October 21, 2022

Re: PA22-040 – 87th & 40th PRD – Technical Review 1
4218 / 4112 / 4018 / 3922 / NNA 87th Ave NE

After preliminary review of the above referenced proposal, the Planning Division has the following comment(s):

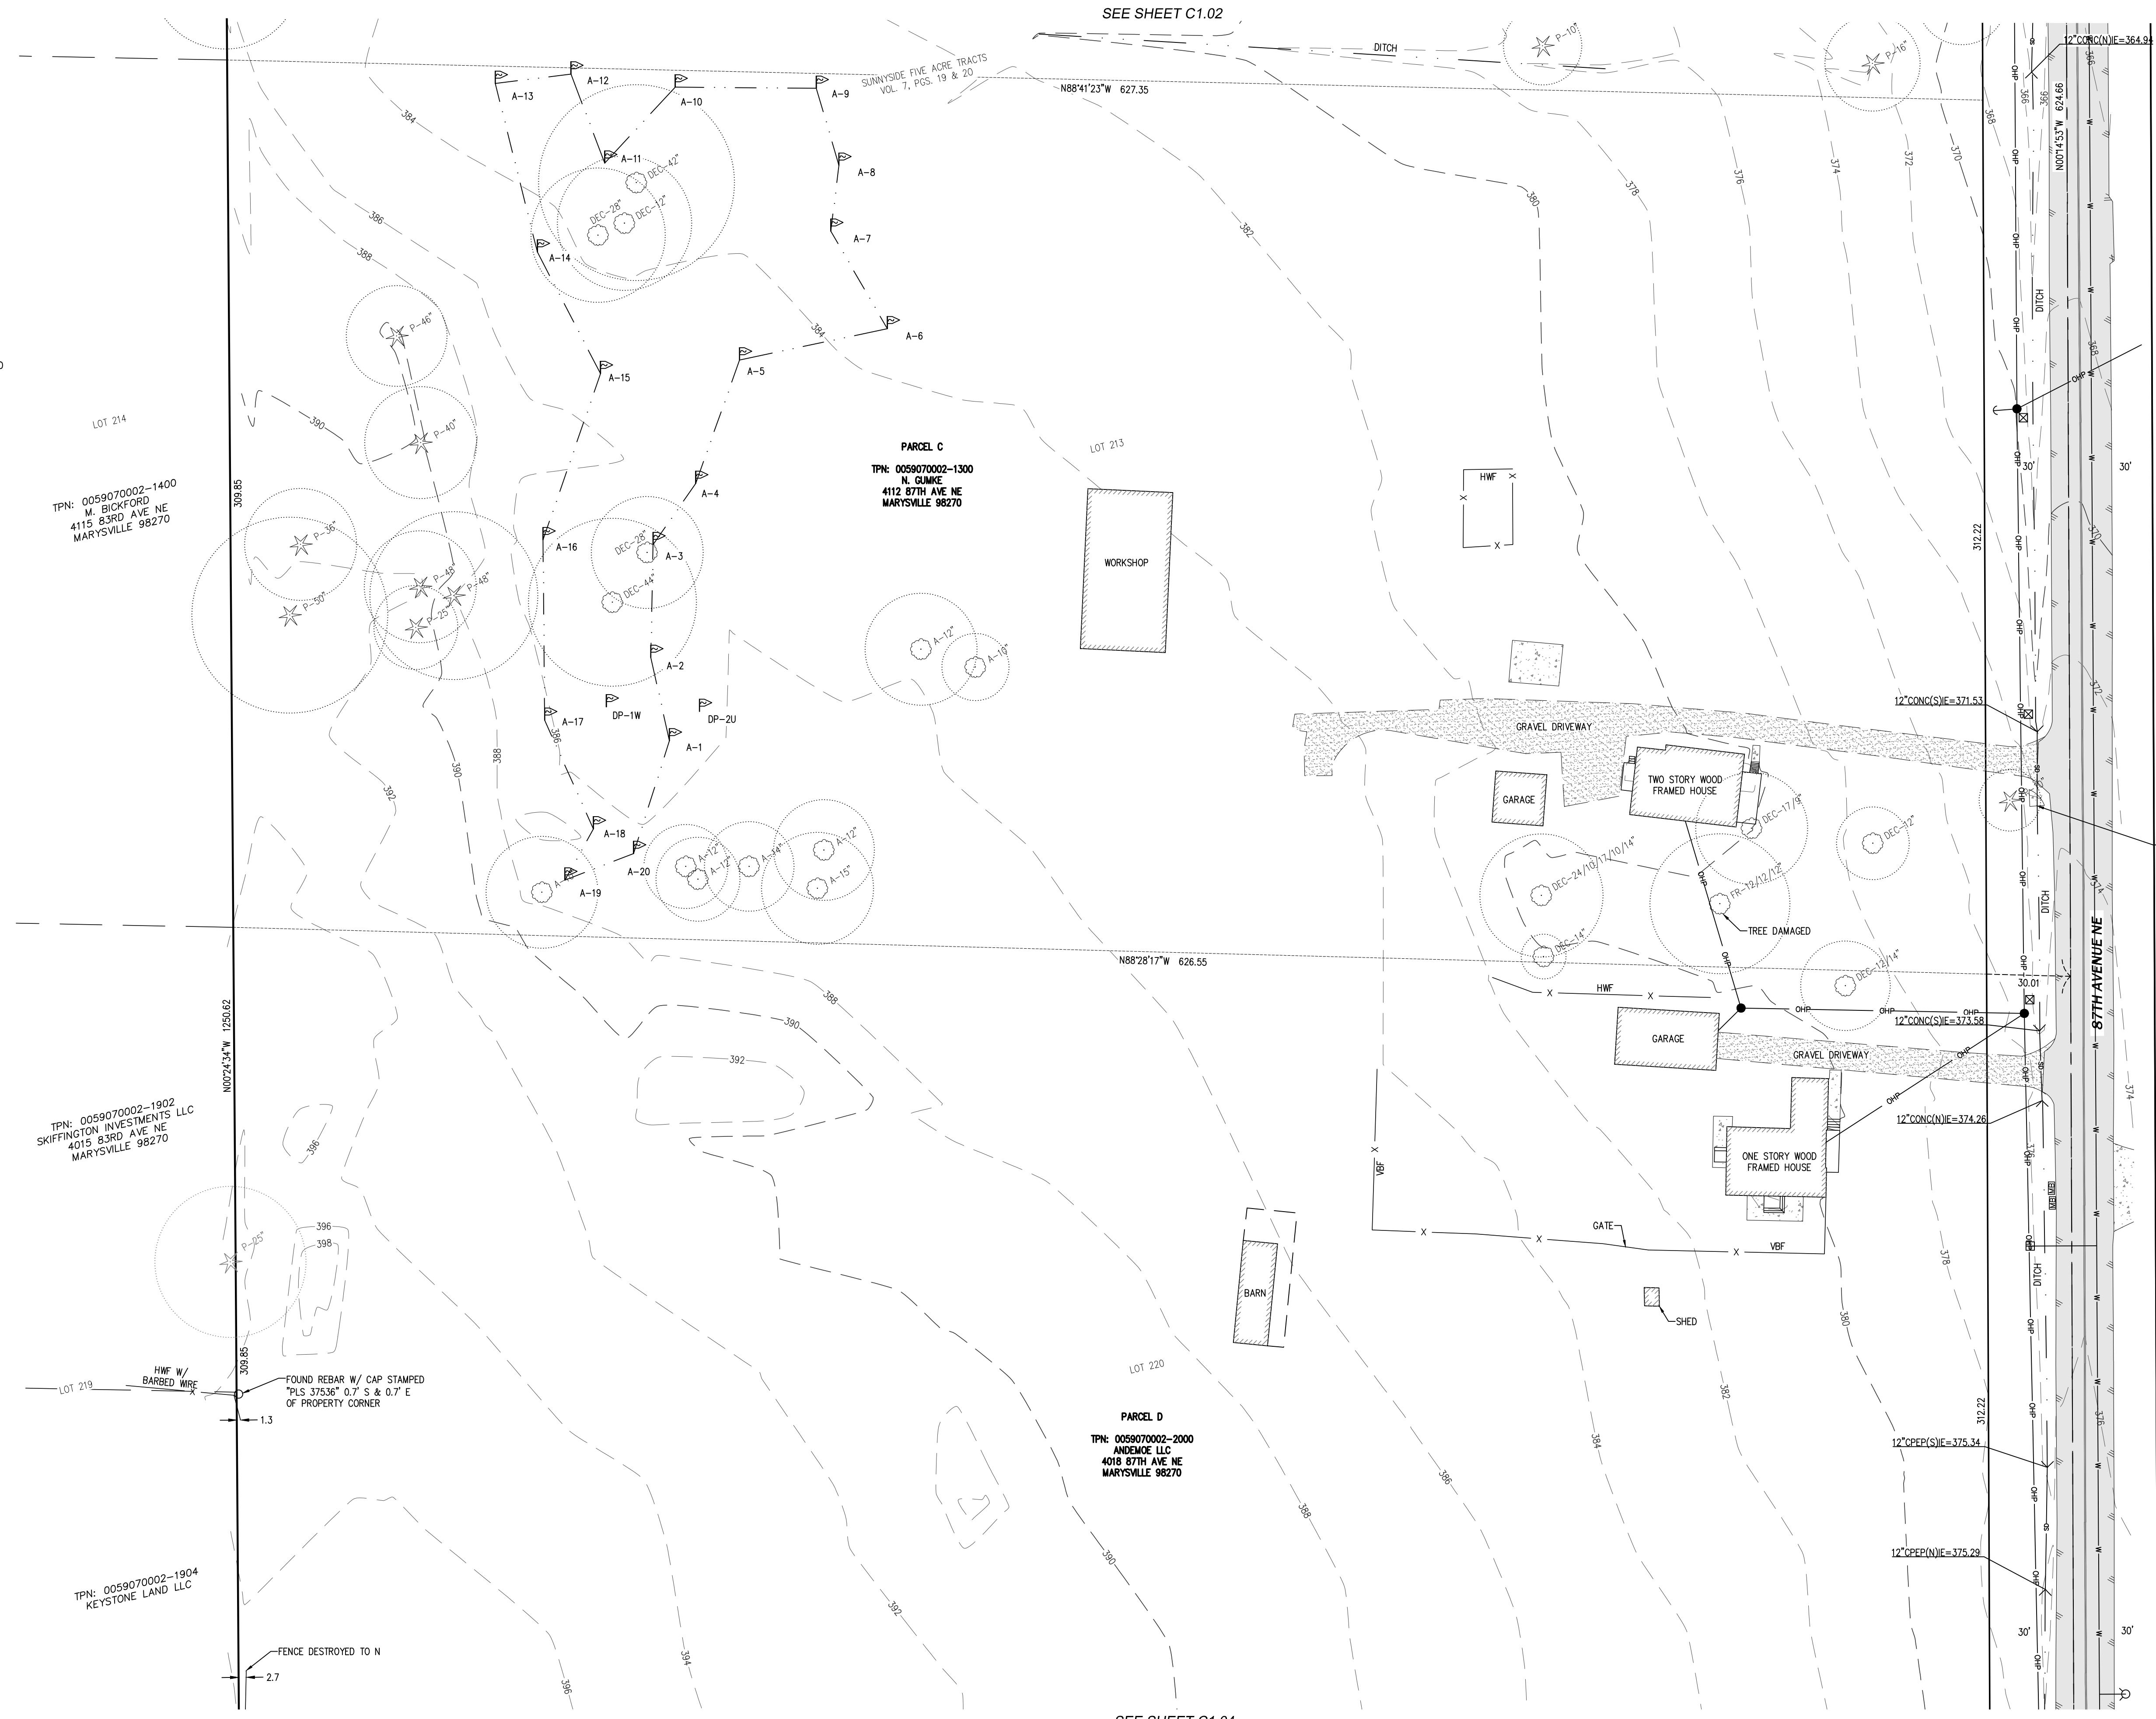
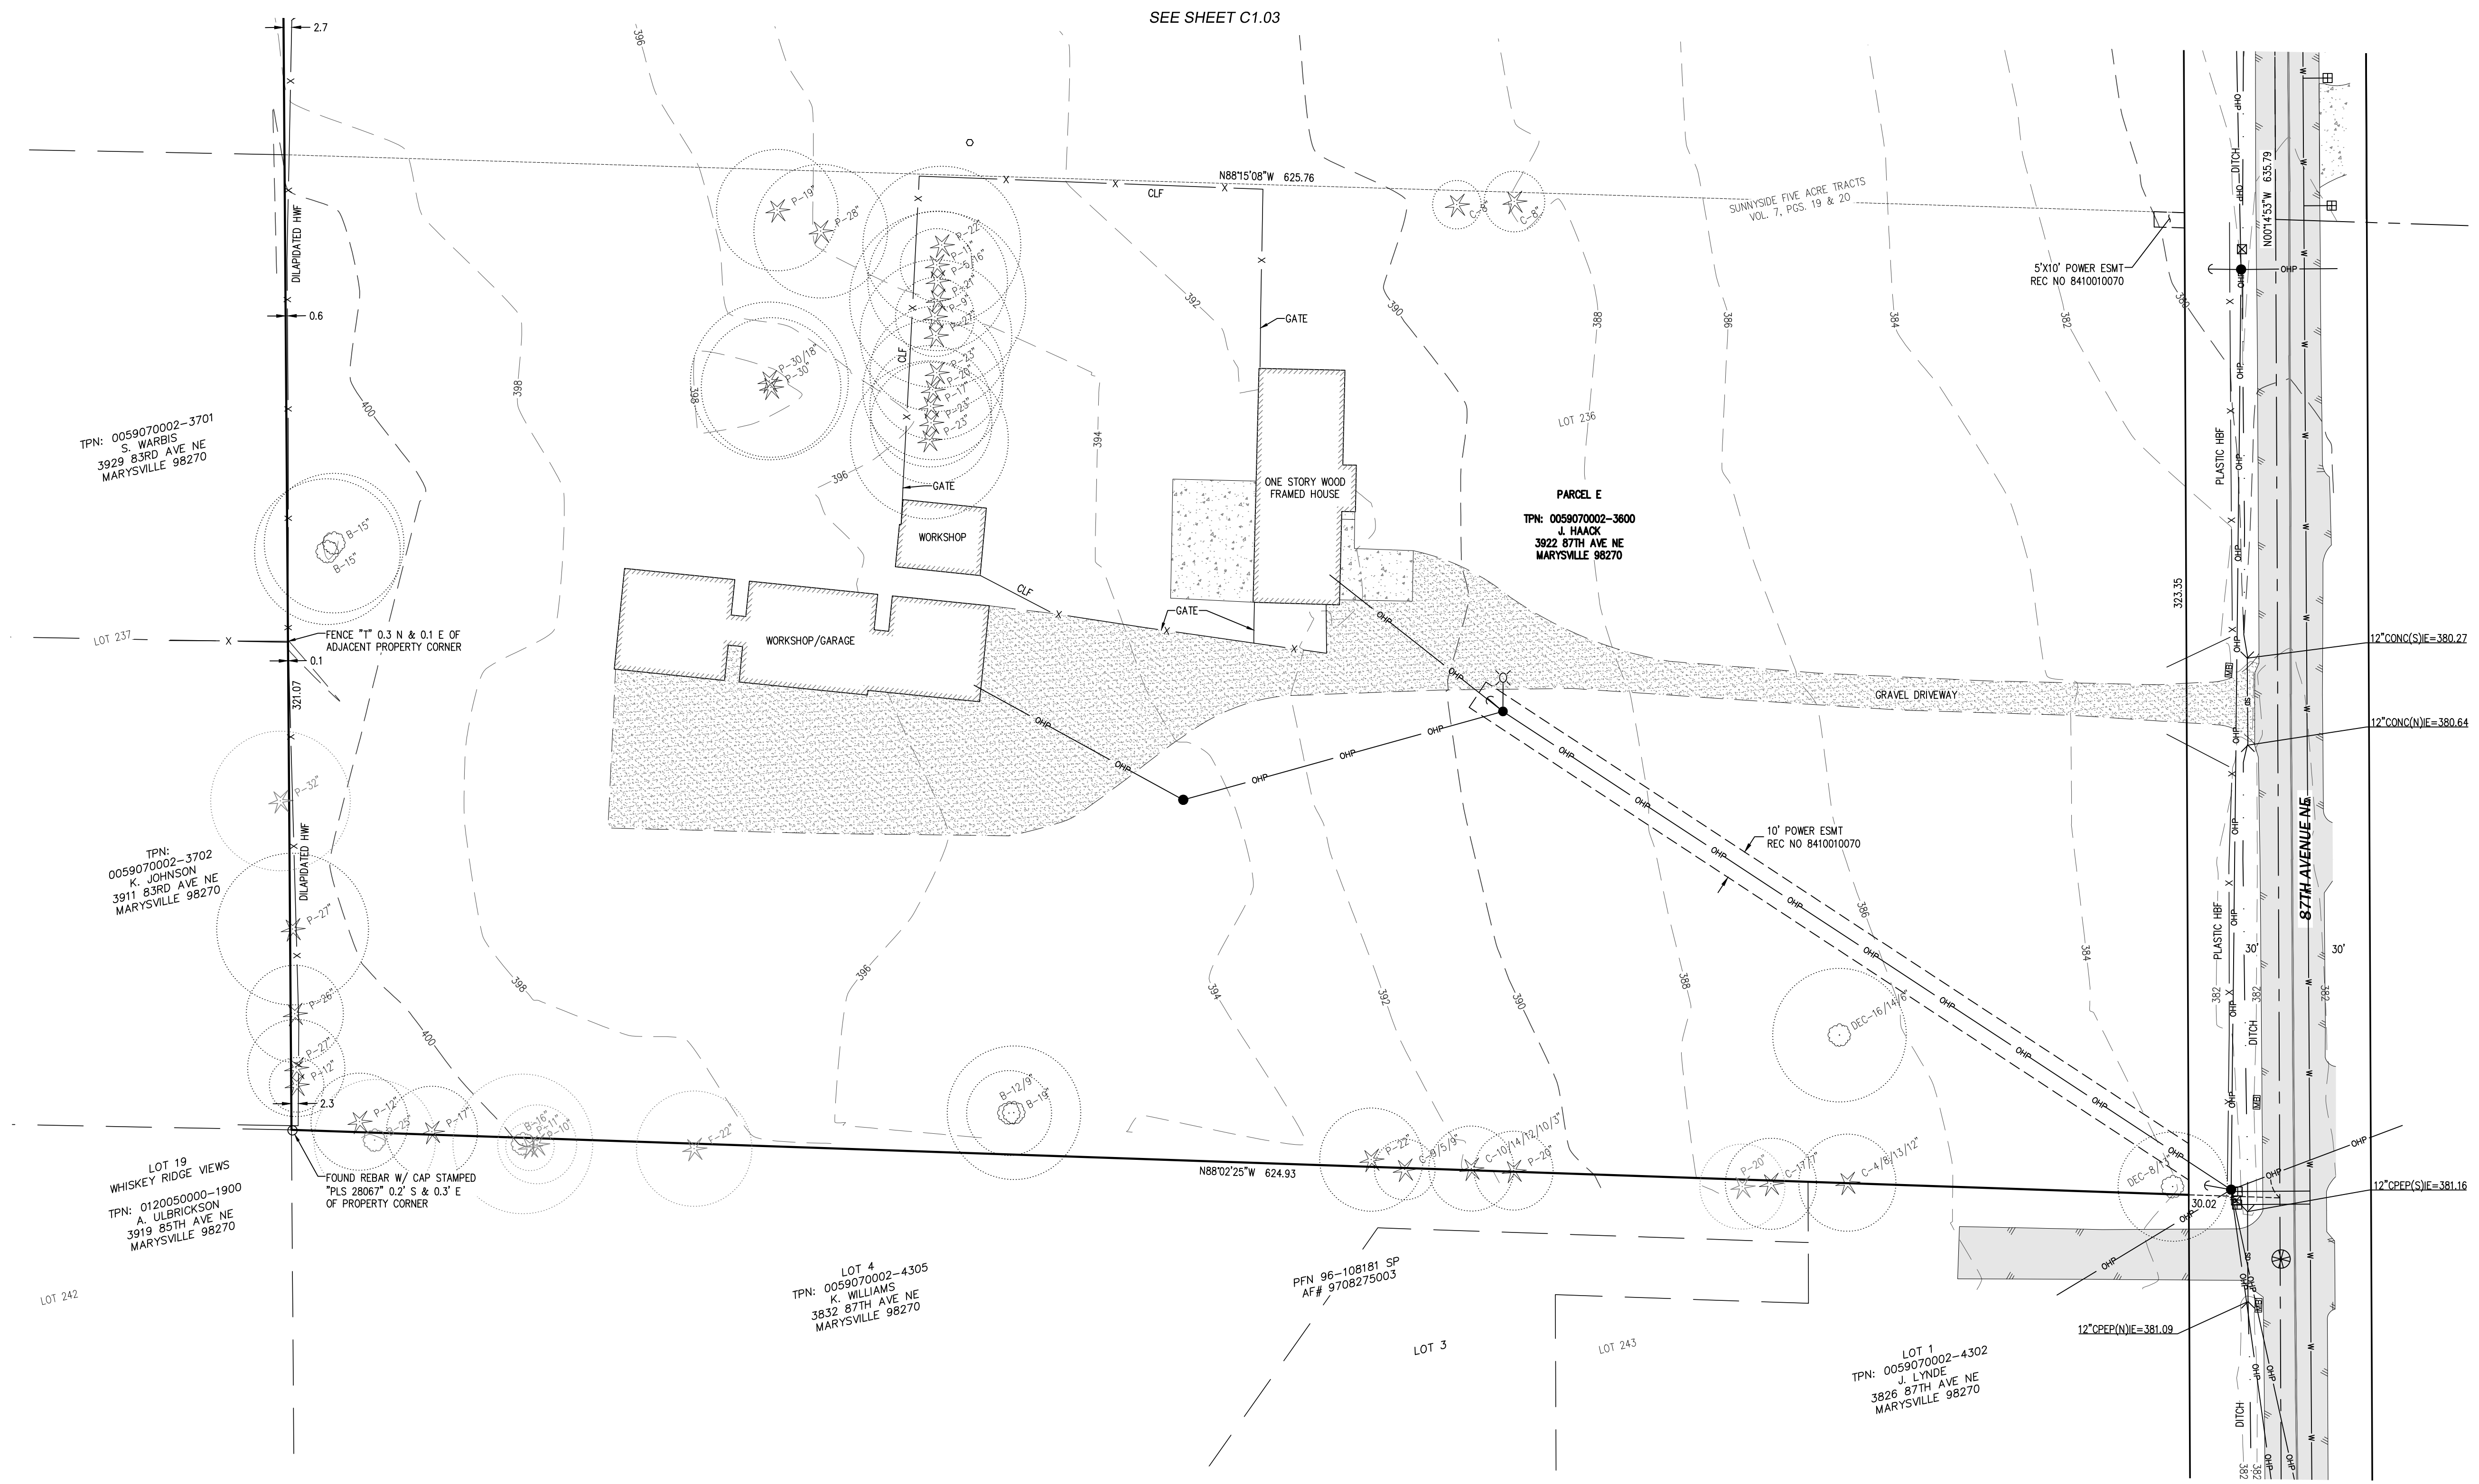
3. Amend Sheets C1.03 & C1.04 to depict all encumbrances outlined in the Title Report, prepared by Chicago Title Insurance Company, dated August 30, 2022. If the encumbrances cannot be depicted they will need to be referenced.

9/15/2022 2:59 PM L:\2021\21036\ENGINEERING\PRELIMINARY\SHEETS\21036_C4.01.DWG

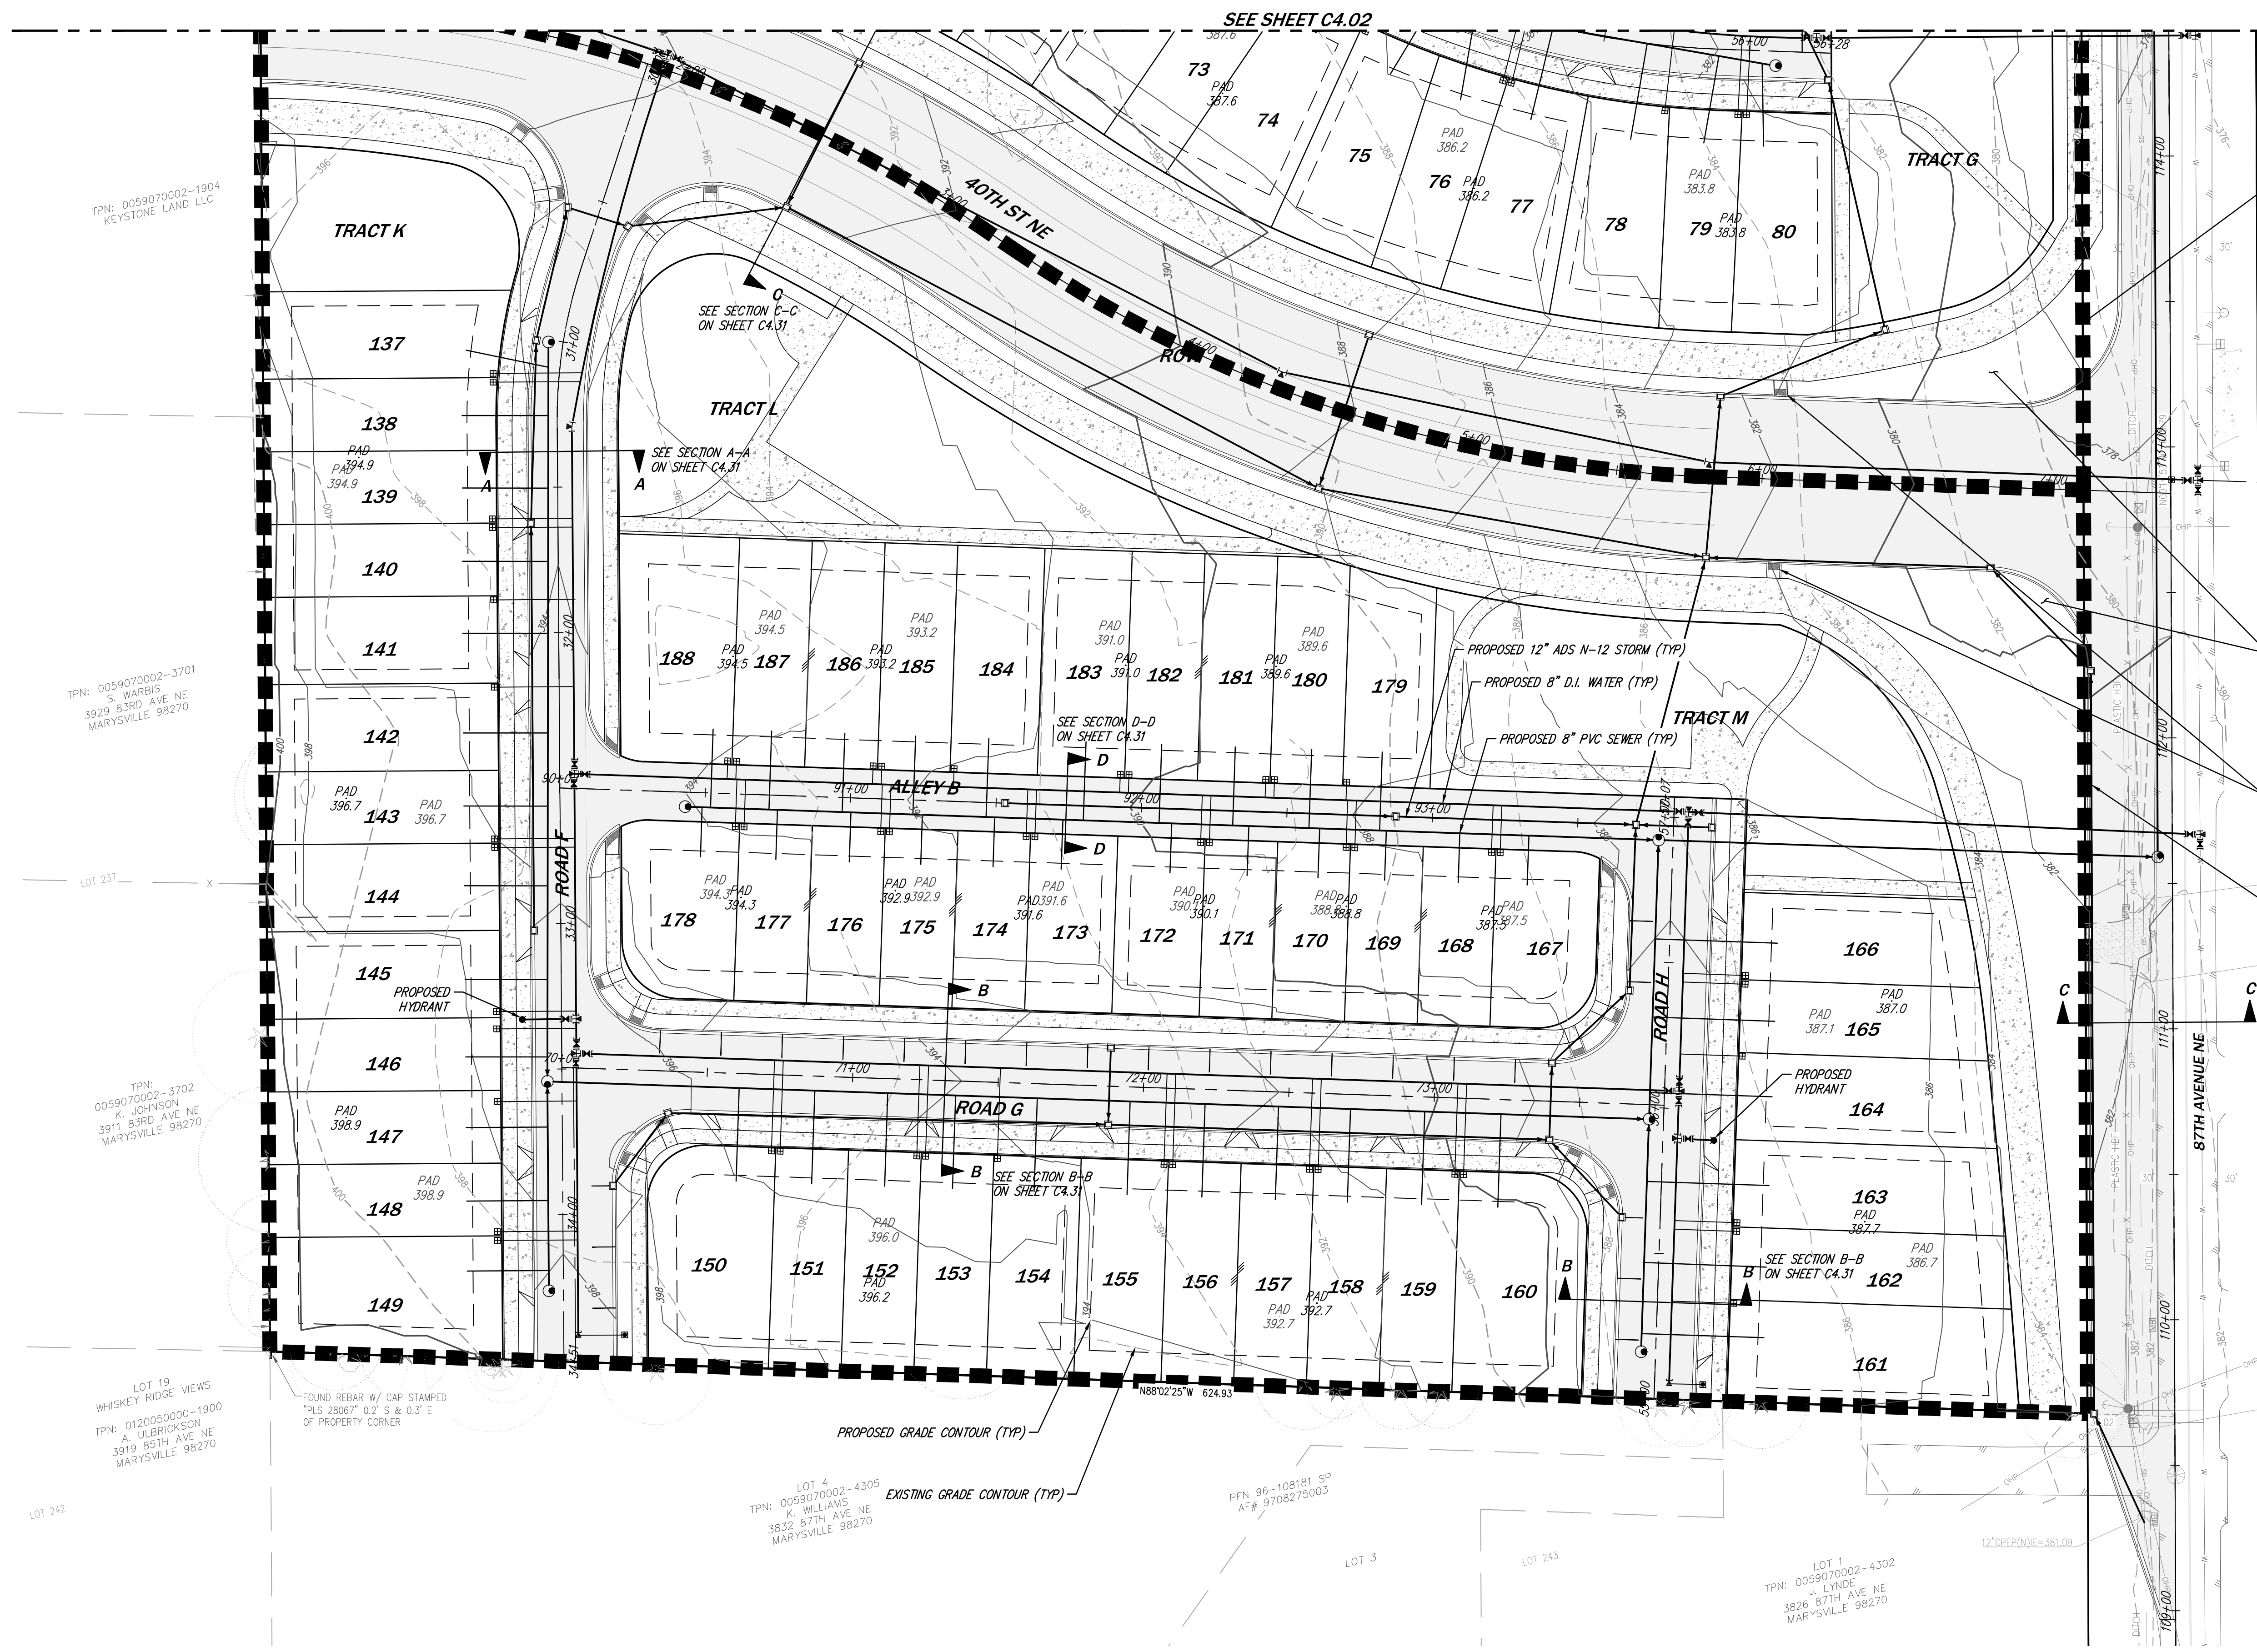
4. On Sheets C4.01 – C4.02 of the civil plans, not all of the open space tracts are labeled. For consistency, please ensure that all tracts are labeled.
